CITY OF ALBUQUERQUE

October 3, 2024

Re: Popeyes Juan Tabo
840 Juan Tabo Blvd NE
Traffic Circulation Layout
Engineer's/Architect's Stamp 9-13-24 (K22D035A)

Based upon the information provided in your submittal received 10-2-24, the above referenced plan cannot be approved for Building Permit until the following comments are addressed:

THIS DRAWING IS INCOMPLETE AND NOT TO BE USED FOR CONSTRUCTION UNLESS IT IS STAMPED, SIGNED AND DATED		
Designed	Drawn	Checked
MJ	DIF	MJ
Date:	September 2024	
Scale:	Horiz: AS SHOWN Vert:	
Project No:	9432731	
Sheet:	C701

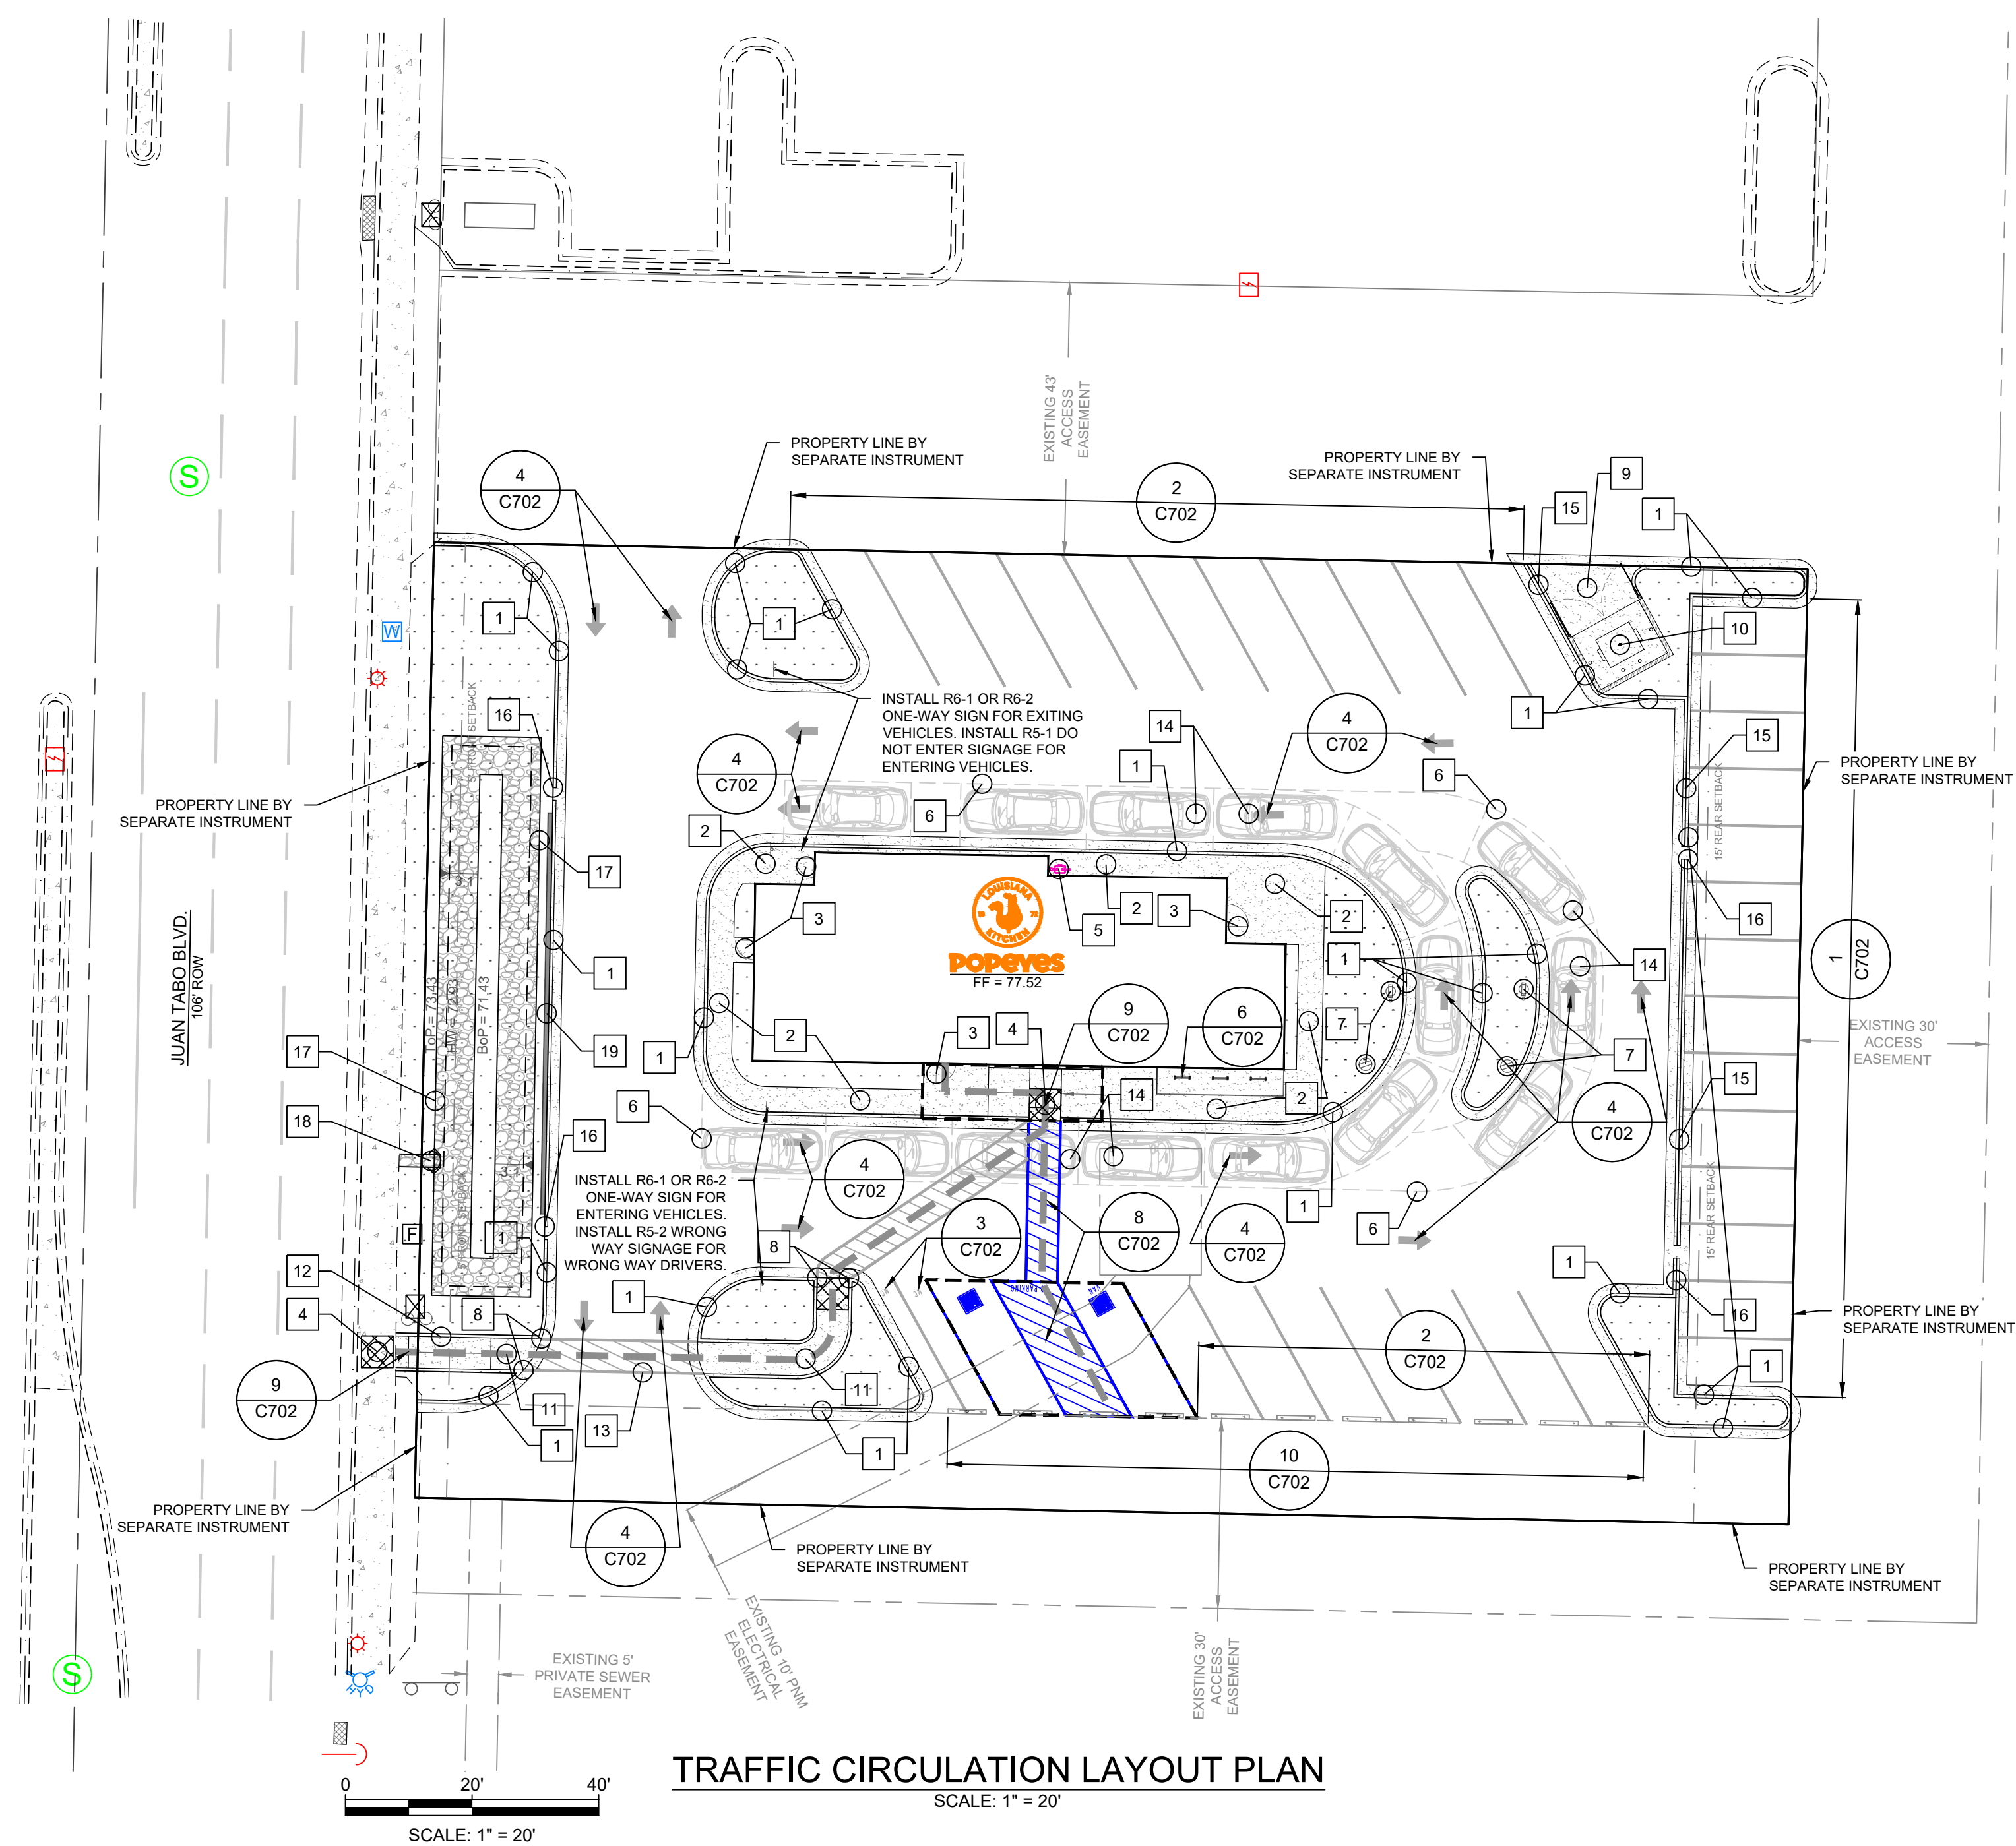
1. Please show a vicinity map showing the location of the development in relation to streets and well known landmarks.
2. Show all the dimensions for the entrances/exits, drive aisles and any other missing dimensions.
3. Please list the width and length for all existing and proposed parking spaces. Some dimensions are not shown.
4. A 1-foot clear zone around the bicycle parking stall shall be provided.

5. Per DPM, a 6 ft. wide ADA accessible pedestrian pathway is required from the ADA parking stall access aisles to the building entrances. Please revise the width to 6' (keyed notes 12 and 13).
6. All one-way drives shall have "One Way" and "Do Not Enter" signage and pavement markings. Please show detail and location of posted signs and striping.
7. The minimum drive through lane width is 12 feet with a 25 foot minimum radius (inside edge) for all turns. (A 15 foot radius can be used with an increase in lane width to 14 feet). Please dimension all lane widths and radii.

8. Show the clear sight triangle and add the following note to the plan: "Landscaping and signage will not interfere with clear sight requirements. Therefore, signs, walls, trees, and shrubbery between 3 and 8 feet tall (as measured from the gutter pan) will not be acceptable in the clear sight triangle."
9. Add a note stating "All broken or cracked sidewalk must be replaced with sidewalk and curb & gutter."
10. Show the existing sidewalk and buffer/landscape widths along Joan Tabo
11. Relocate the parking blocks (Stops) by 60 deg angle and 2' away from end of the parking stall. Add parking blocks (Stops) for the north side parking stalls.
12. Provide approval of solid waste dept and fire marshal.
